Our Ref: LU/332/19/HH
Your Ref:

Town & Country Planning Act 1990 (as amended)
Town & Country Planning (Development Management Procedure) (England) Order 2015
Application for Planning Permission for Works or Extension to a Dwelling

Development Single storey rear extension
Location 1 Swanwick Walk Manning Road Littlehampton

1, Swanwick Walk, Manning Road, Littlehampton, West Sussex, BN17 7FF

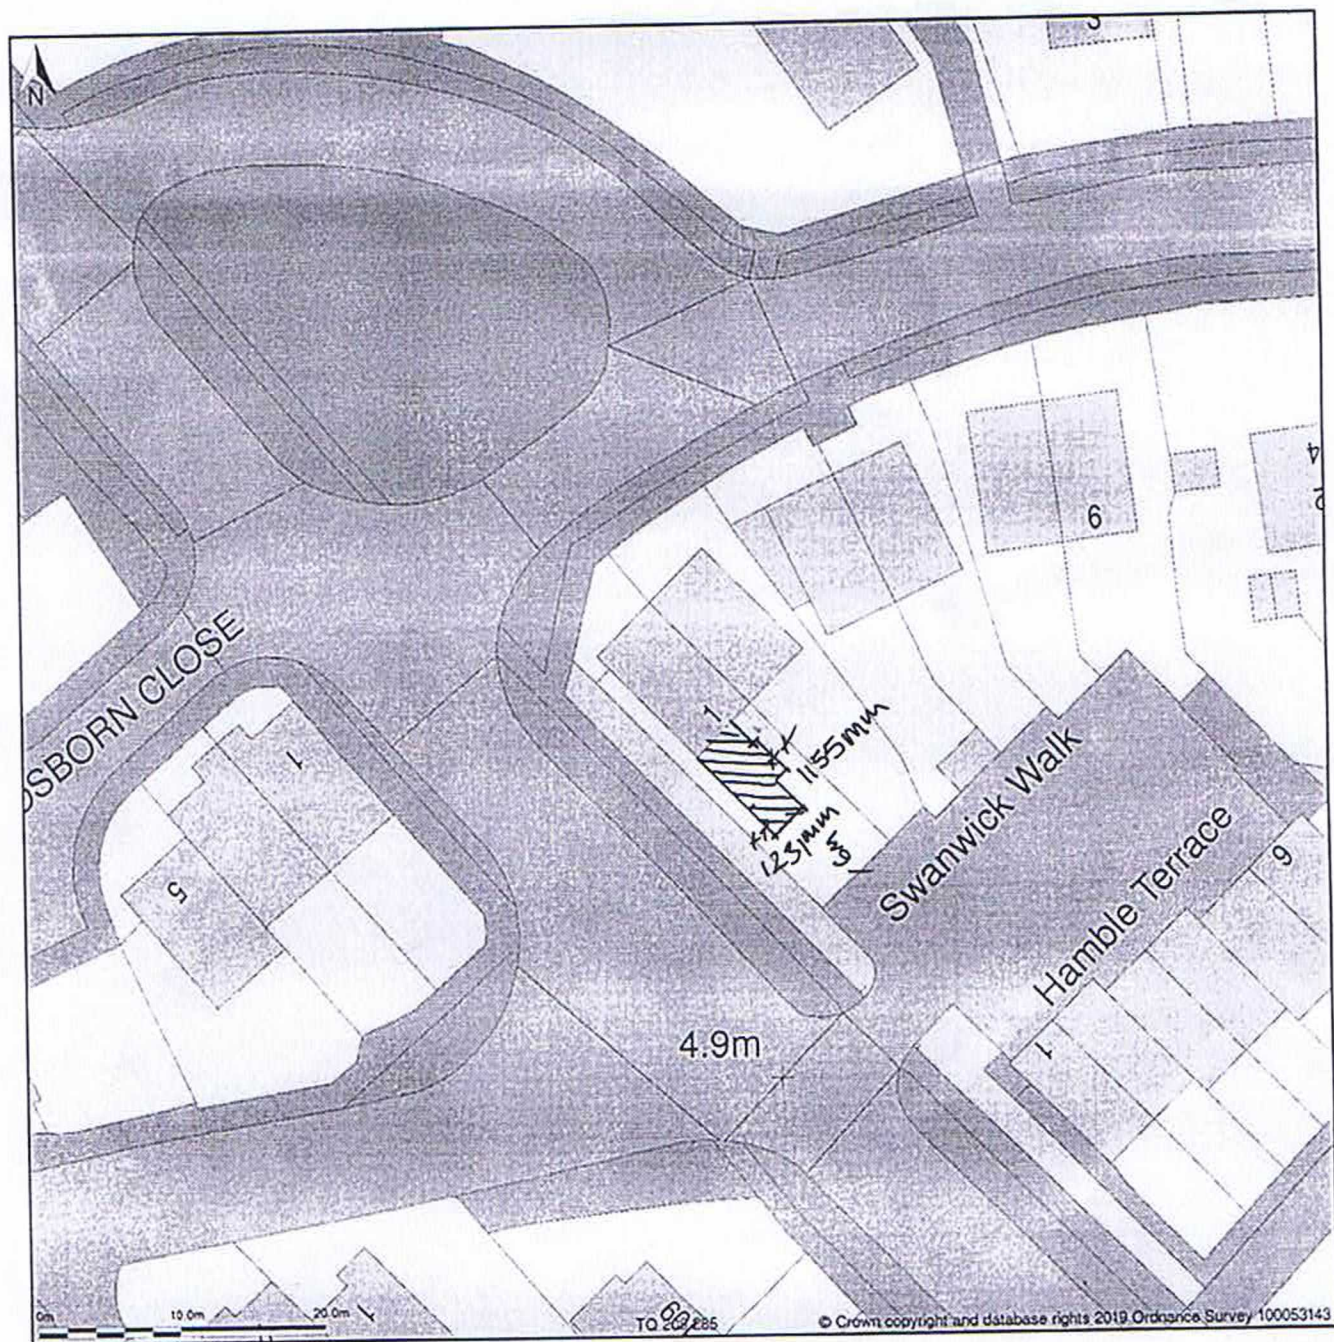
Block Plan

You are required to submit a block plan with dimensions from the proposed extension to all site boundaries.
